CITY OF ALBUQUERQUE

June 6, 2016

**RE: Kerschen Dental Office
Grading and Drainage Plan
Engineer's Stamp Date 4-28-2016 (File: C19D064)**

GRADING AND DRAINAGE PLAN

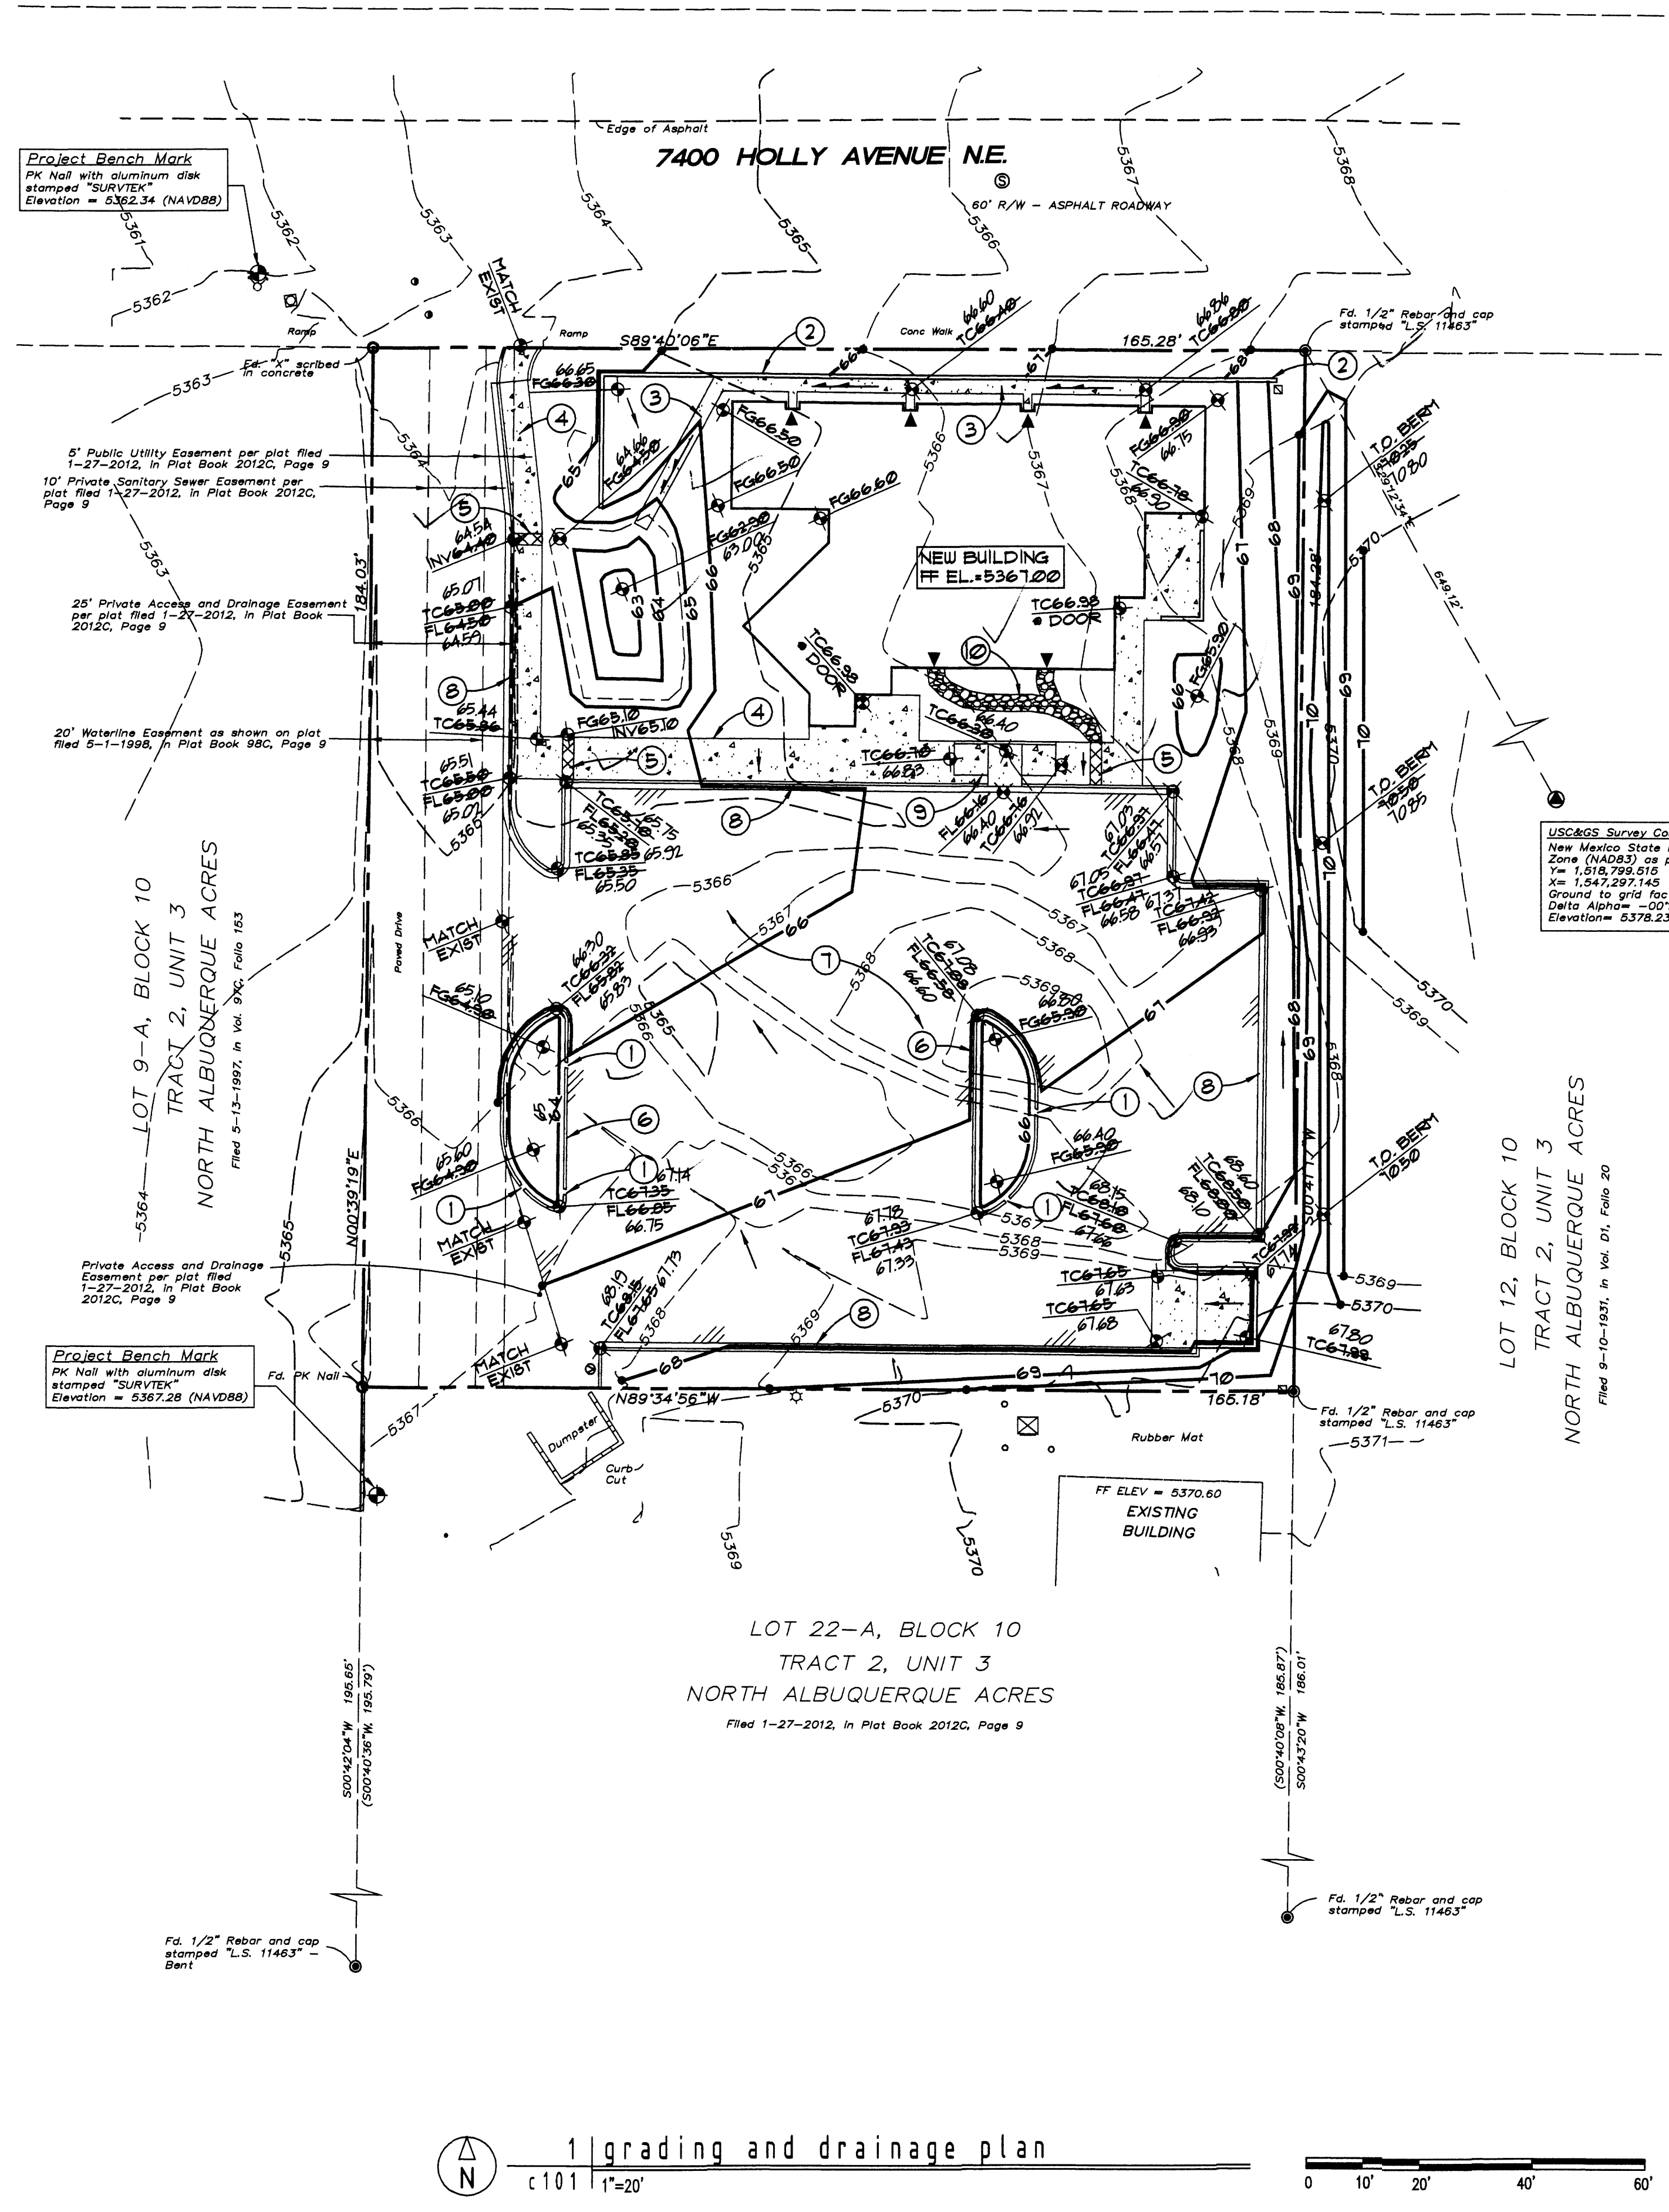
Please ensure that the berm work on the adjacent property is shown on the as-built sets.
